Your Ref: SSD-8636-Mod-2
Our Ref: R/2018/7/C
File No: 2020/309337

New Request for Advice – University of Sydney – Engineering & Technology Precinct – SSD 8636 Modification 2

BON068: 1% AEP FLOOD LEVEL
AFFLUX PROPOSED - EXISTING

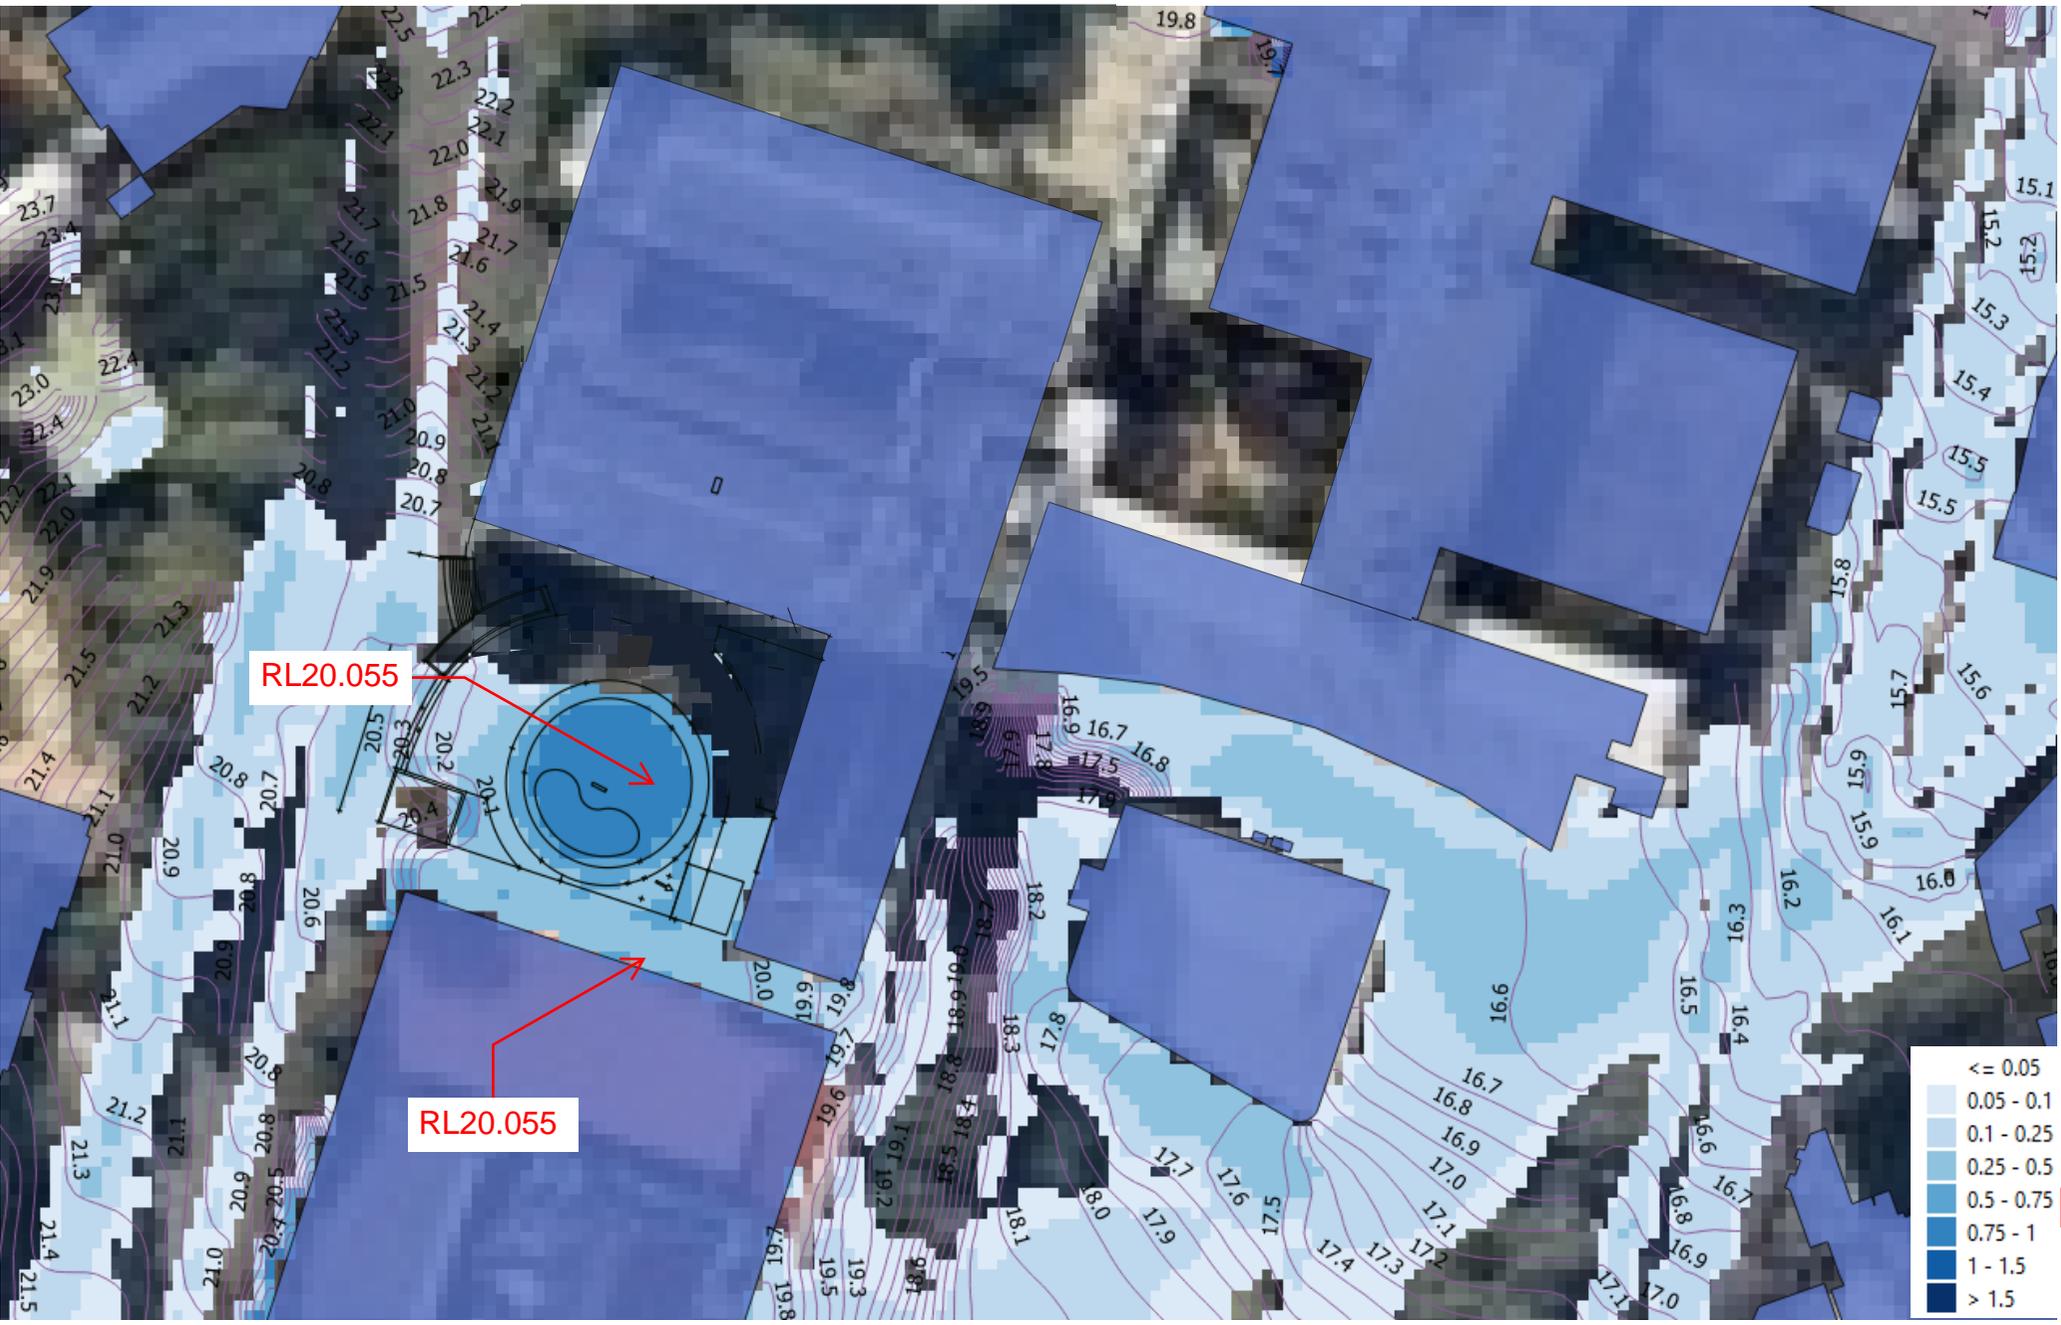
- **Condition B37** – Section 4.1 of the submitted SJB Planning Report states the request for deletion of Clause 37 is supported by additional flood modelling “which indicates that the development does not result in an increase in flood affectation for the existing Electrical Engineering Building”. However, Figure 5 (shown below) of the of the Flood Investigation – Basin D Removal report, shows a significant increase in flood depth (shown red) just outside the building. The City seeks clarification on this.

There is insufficient information provided at this stage to determine if the City can support the removal of this condition. Section 3.1, paragraph 2 of the Flood Investigation – Basin D Removal report, notes that this basin was for the purpose of both flood mitigation and water quality treatment. It is noted that the On Site Detention (OSD) being proposed as an alternative is to include bio-retention for water quality treatment. It is therefore possible that this alternative is acceptable but there is insufficient information given to conclude if it is capable of the same performance of the previously proposed basin.

Proposed plan - South Plaza

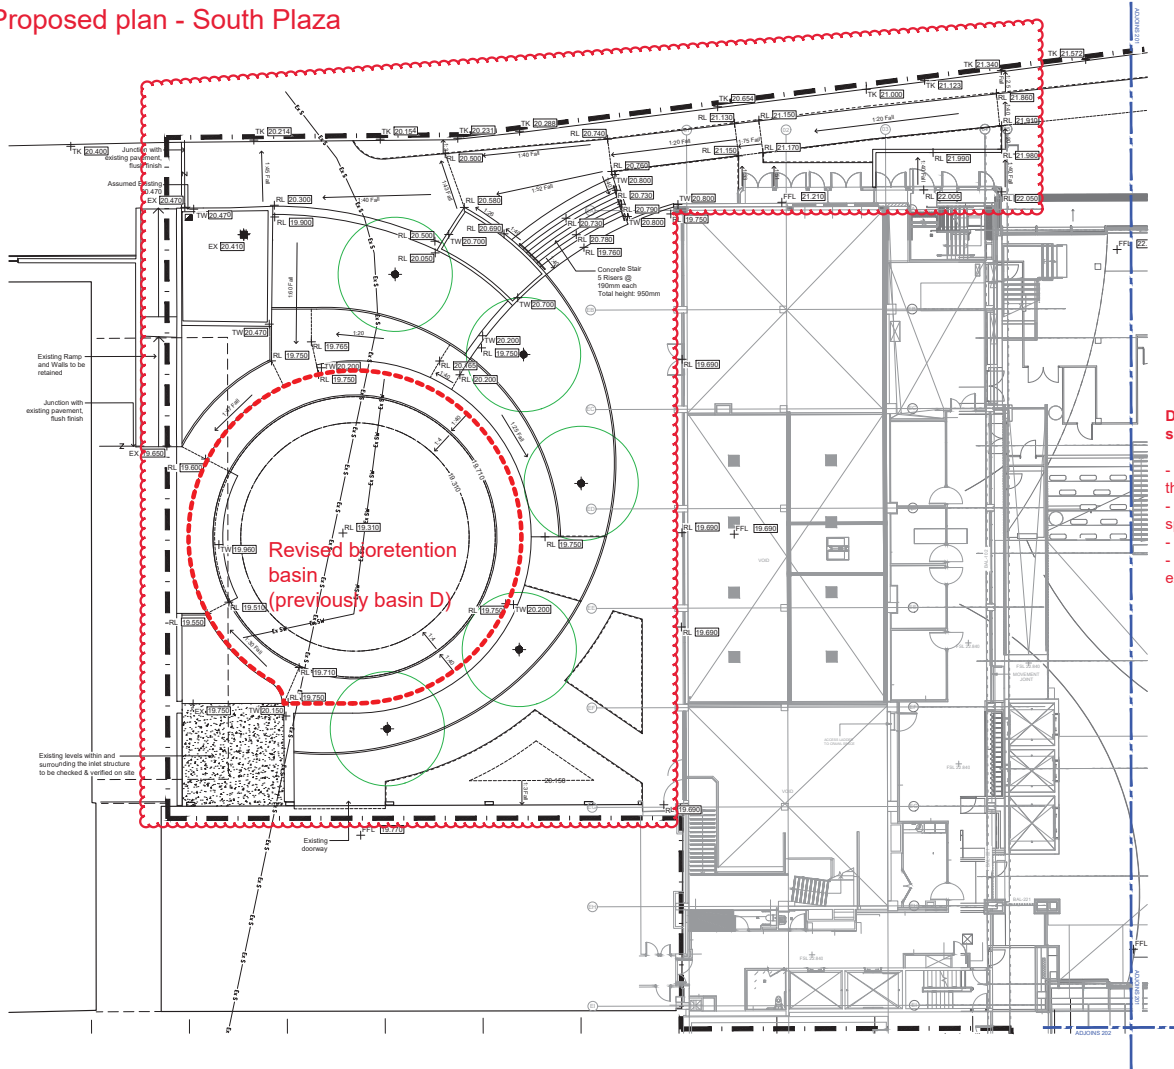
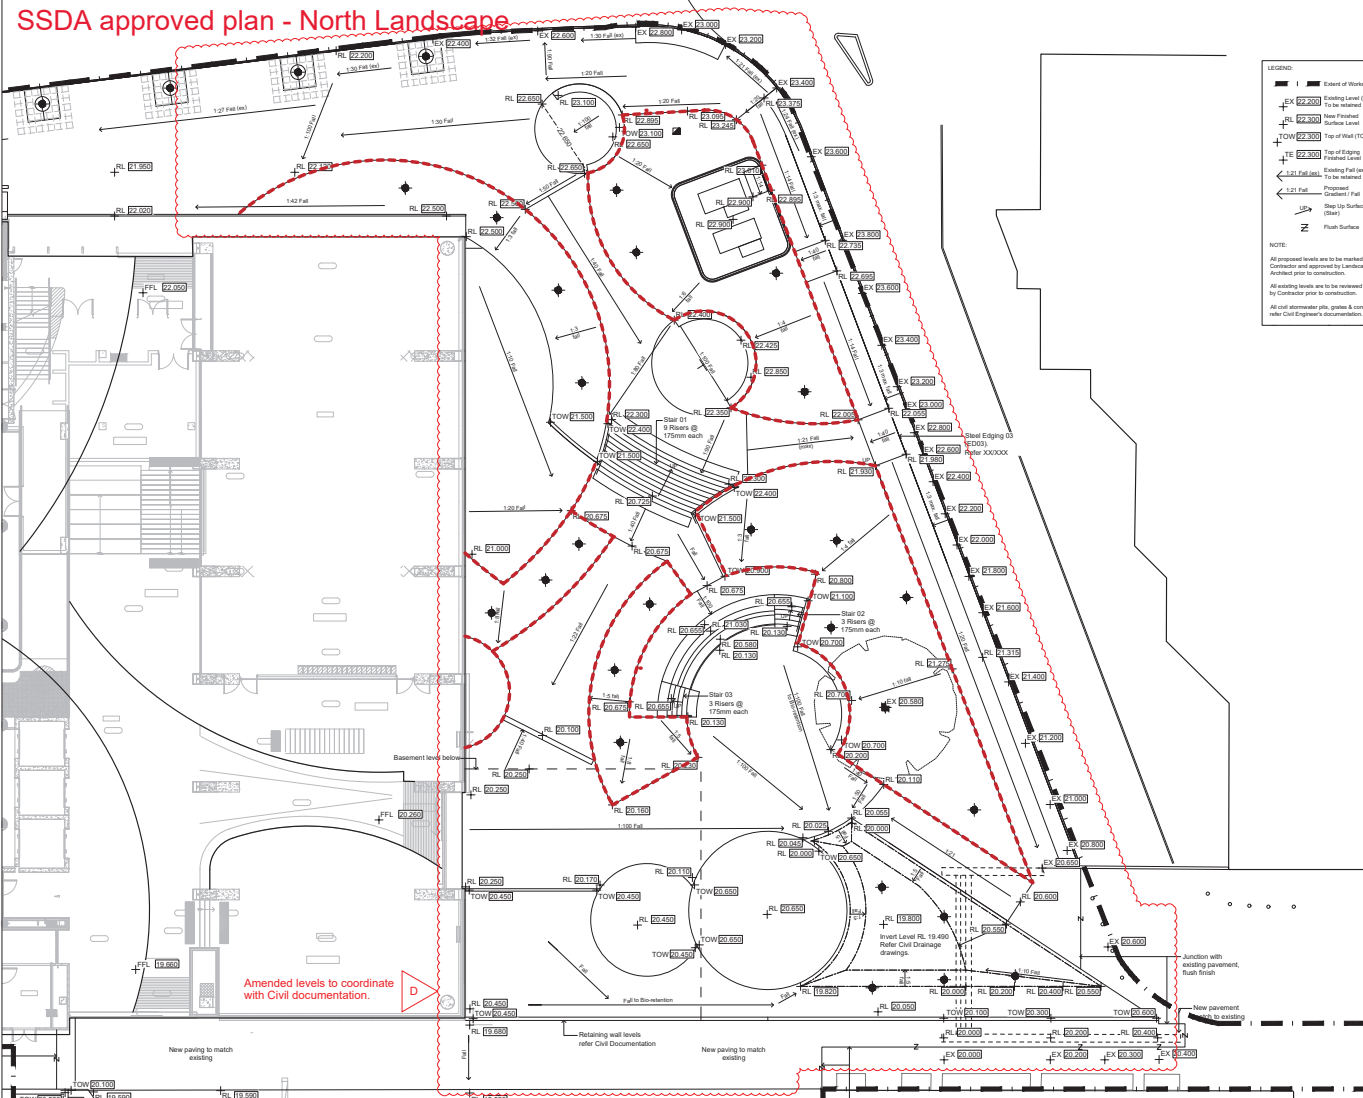
Additionally, if the flood risk is removed by retention and renovation of the existing engineering building, it is not clear what changes have been made to the landscape design, levels and edge treatments for the Southern Plaza bio-retention basin. The Southern Plaza plans do not provide sufficient levels and gradients for the pavements, sections and details to confirm DDA compliant equitable access on the surrounding paths, and that the risk of people tripping or falling into the basin has been "designed out" of the scheme.

The City requests that detailed plans with sections, levels and proposed edges are submitted to resolve this issue and demonstrate the amended design is DDA compliant and fit for use.
